Rezoning Transportation Analysis

Petition Number: Insert Zoning Petition #2021-260

Date	Description
04-18-2022	First Review (WB)
05-25-2022	Second Review (WB)

DATE: 11/03/2021  
DESIGNED BY: CMG  
DRAWN BY: JYK  
CHECKED BY: JYK  
SCALE: 1/8" = 1'-0"  
PROJECT #1021366  
SHEET #:

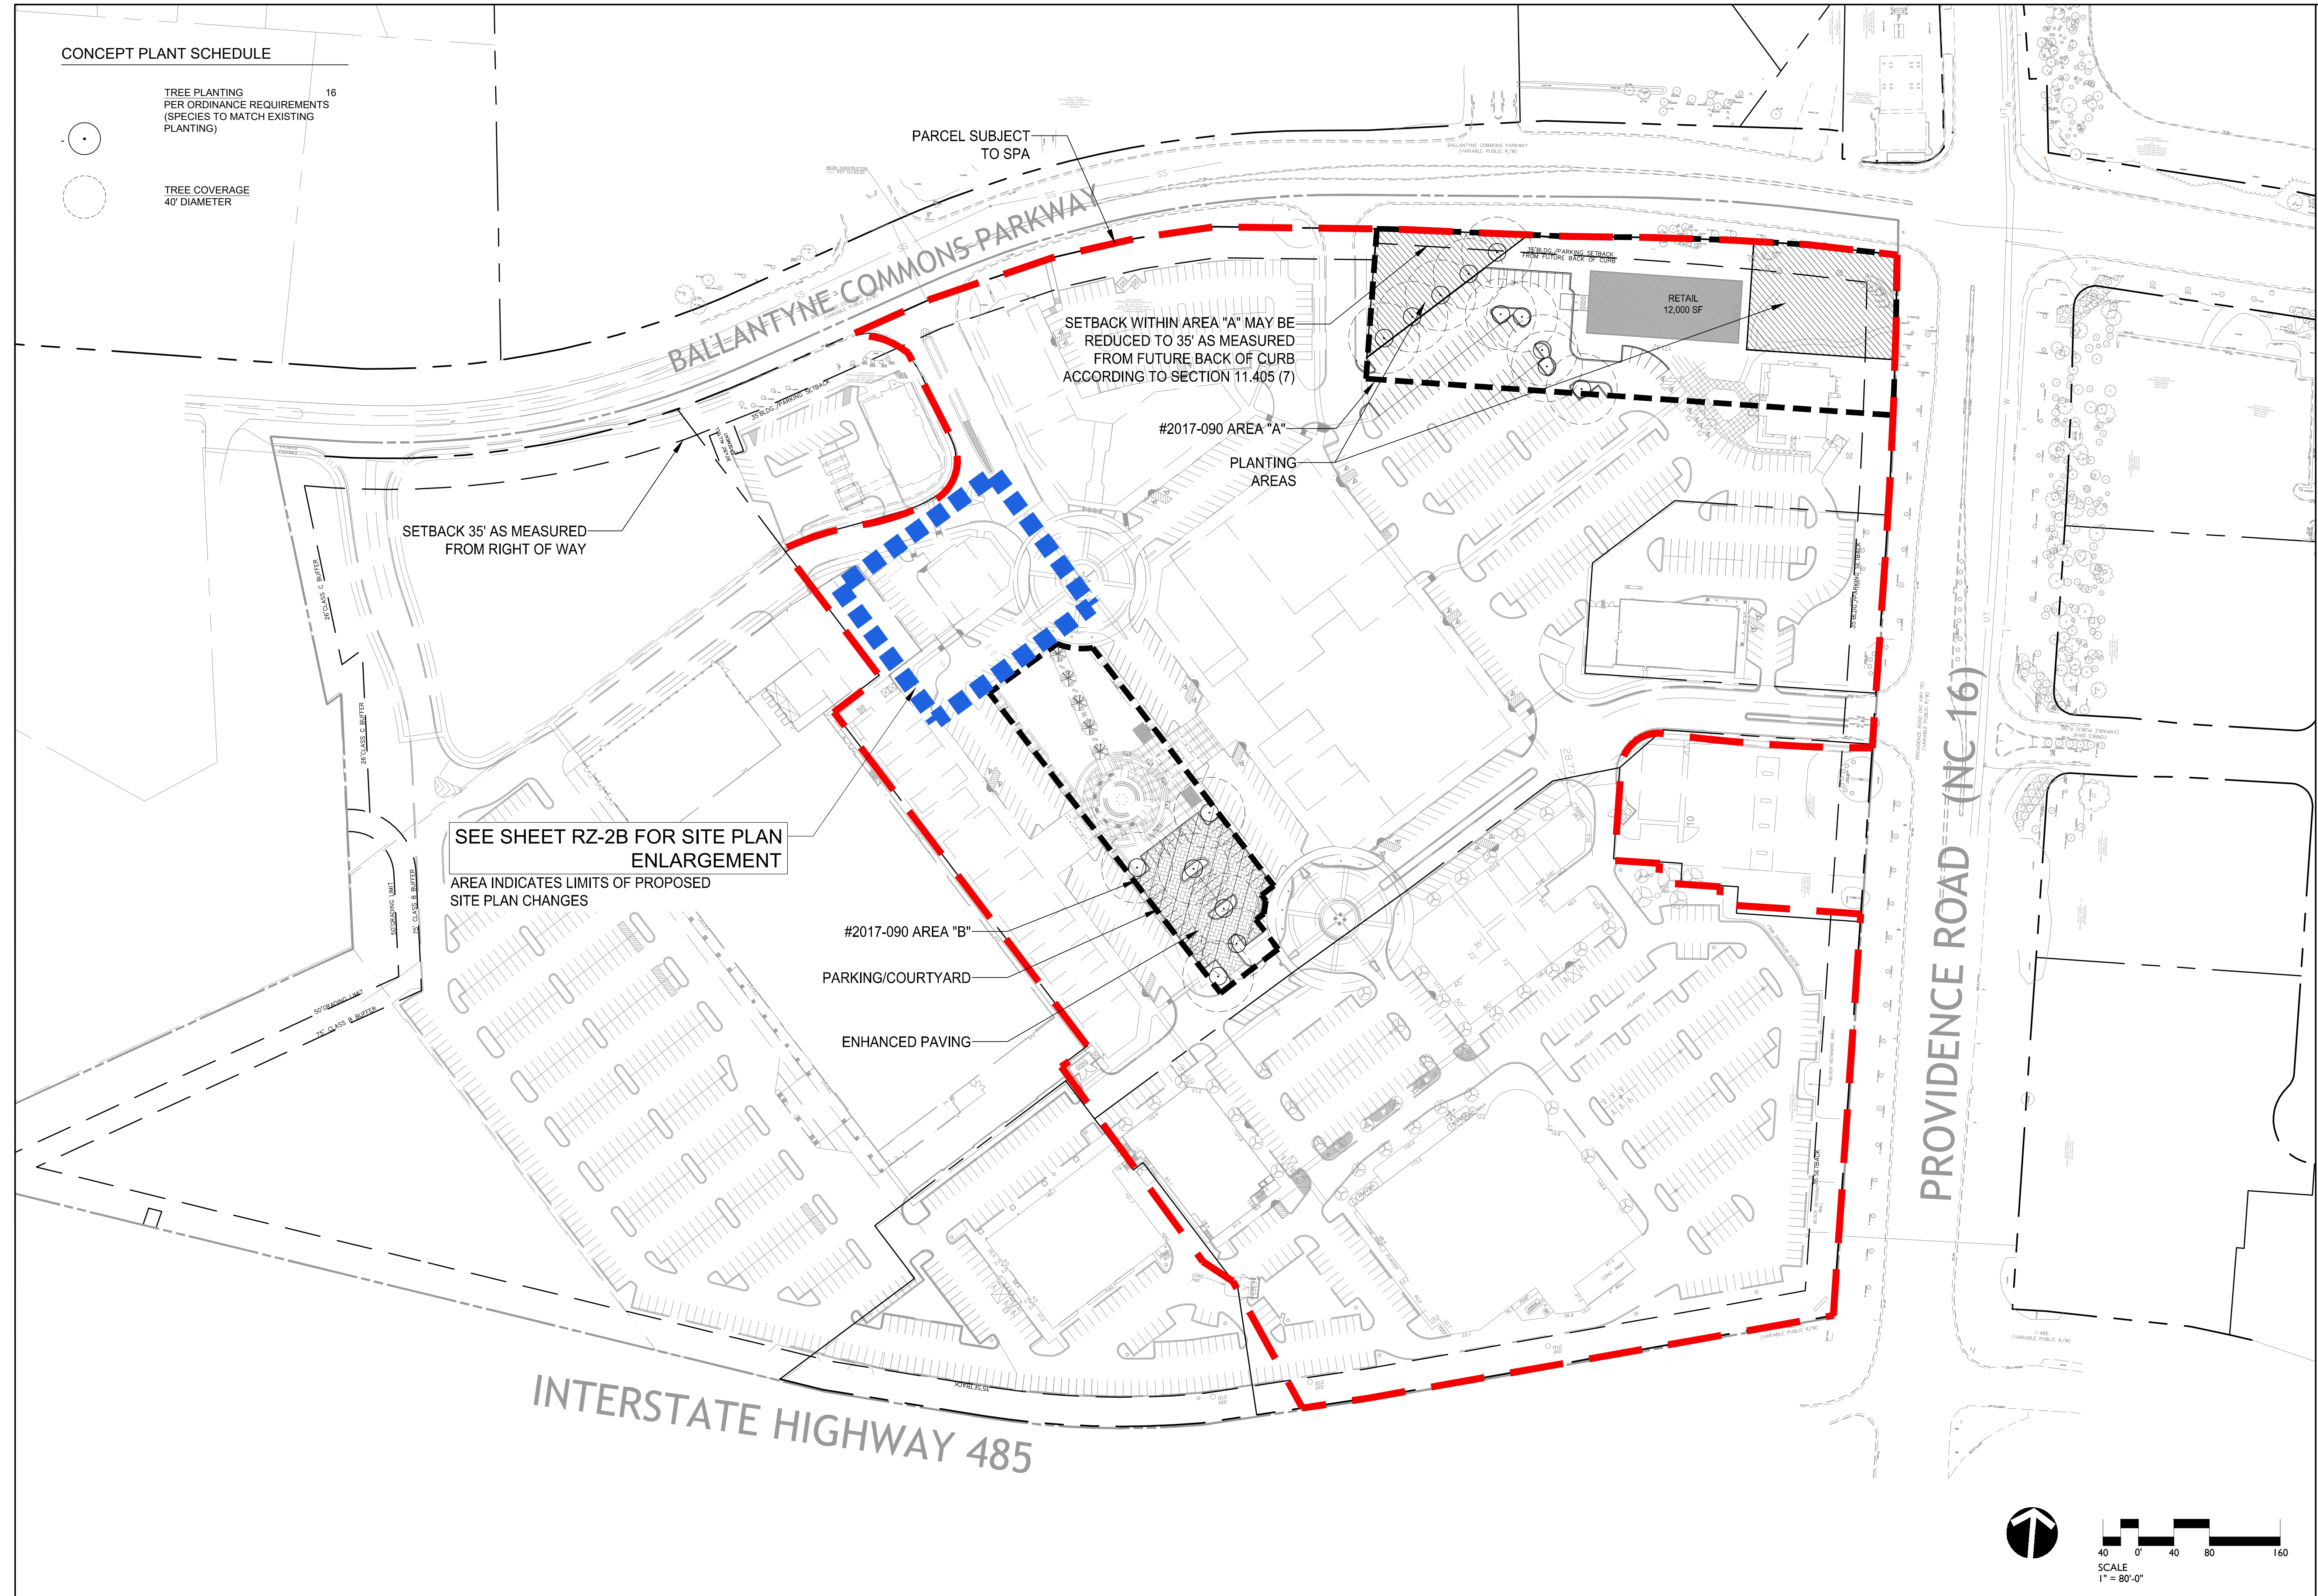
1. **Curblineline:** The proposed zoning district has a setback measured from back of the existing or proposed future curblineline.
 - a. **Ballantyne Commons Parkway:** The existing curb and gutter is in its future location.
 - b. **Providence Road:** The existing curb and gutter is in its future location.

Label and dimension the curb and gutter from the centerline for each road on the site plan.

SHEET #:  
**RZ-2B**

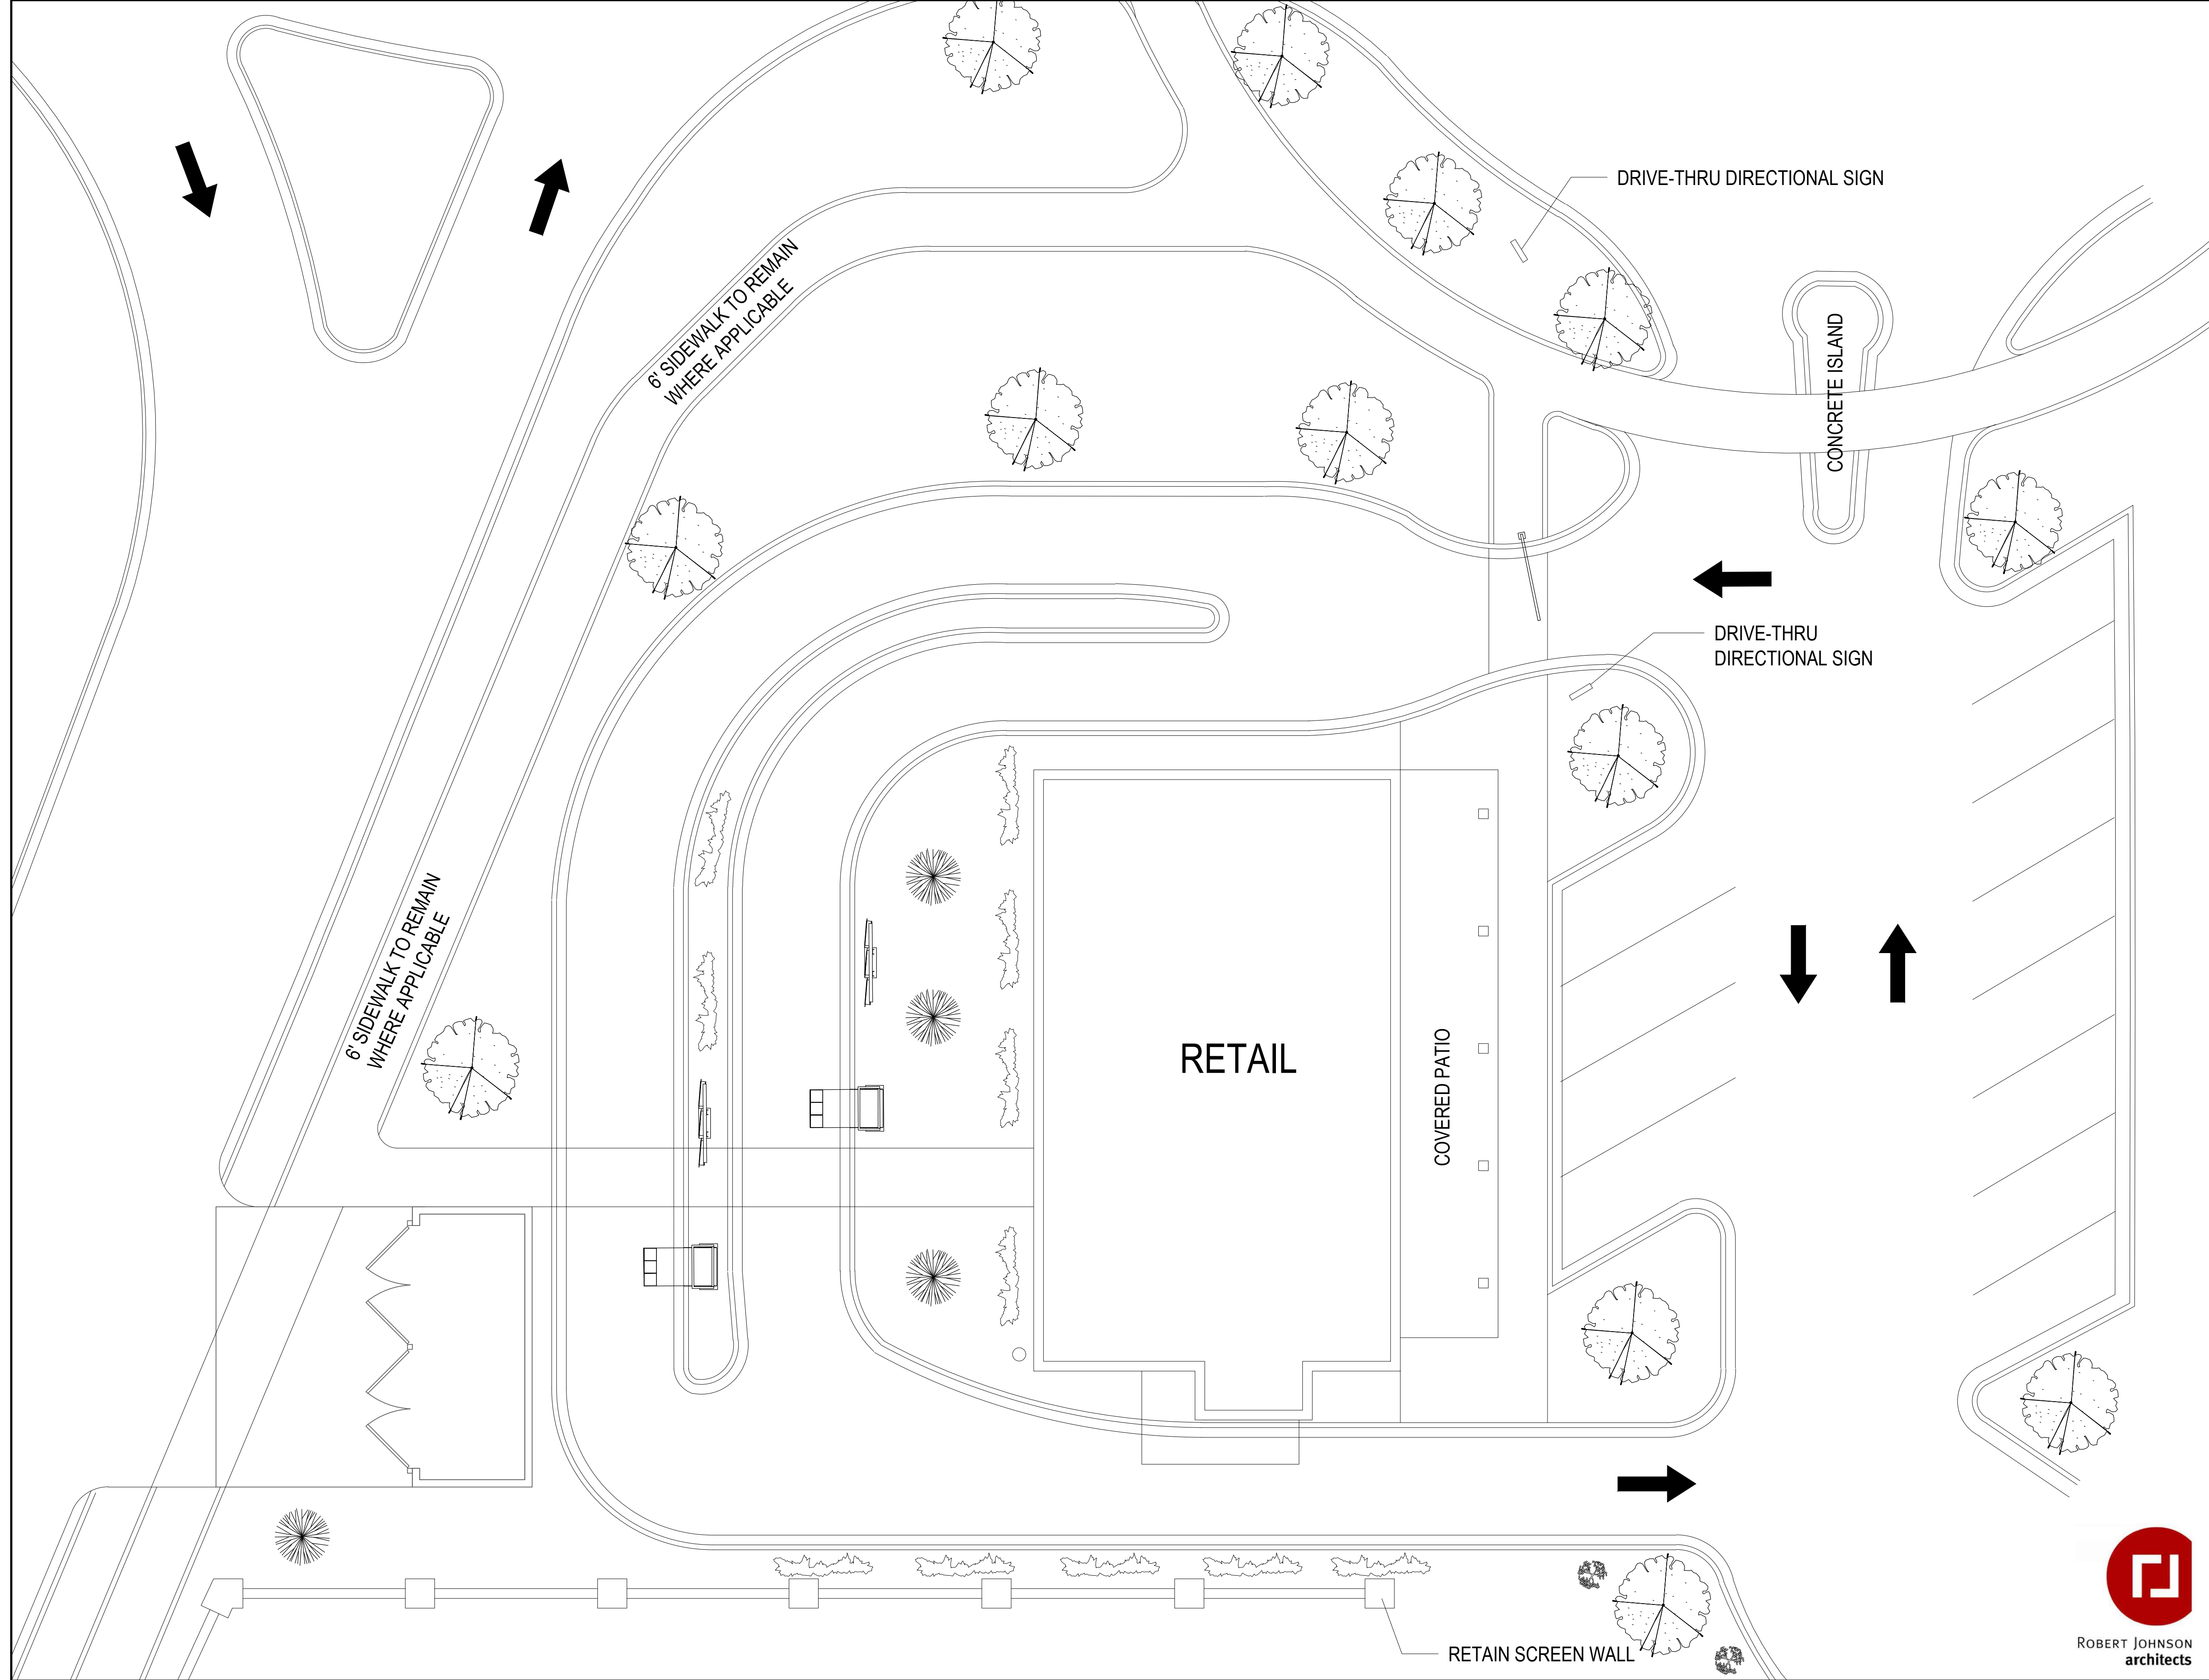
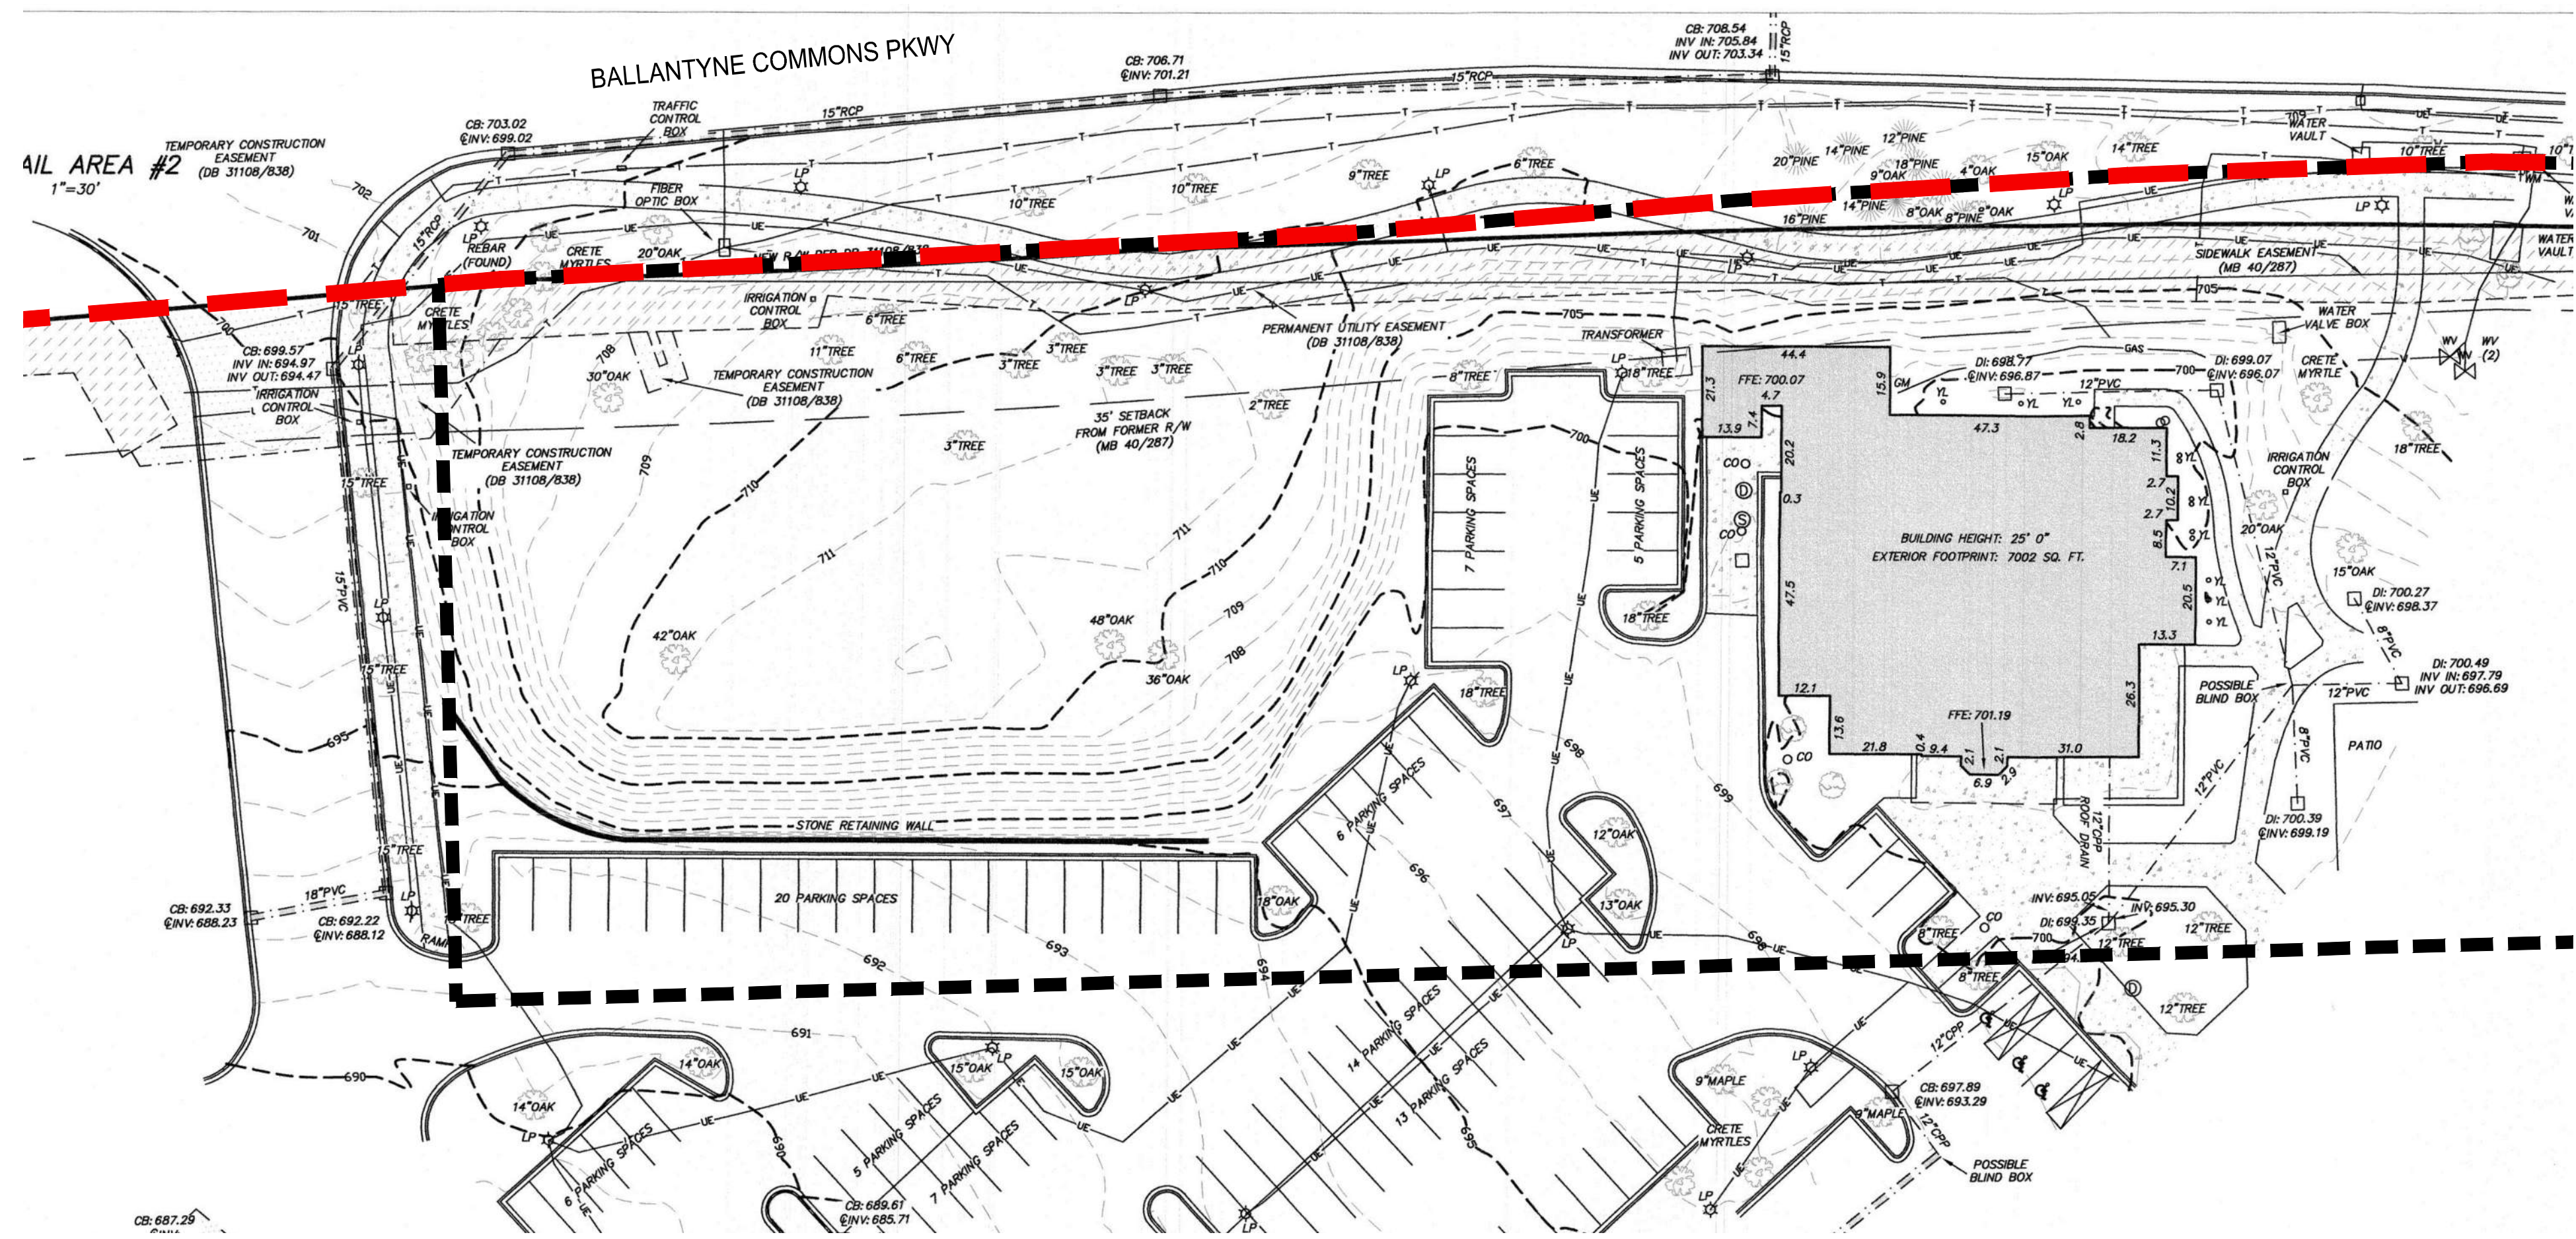
3. Revise site plan and conditional notes to provide on-site stacking without queueing within the roundabout or the Promenade Drive stem toward Ballantyne Commons Parkway.
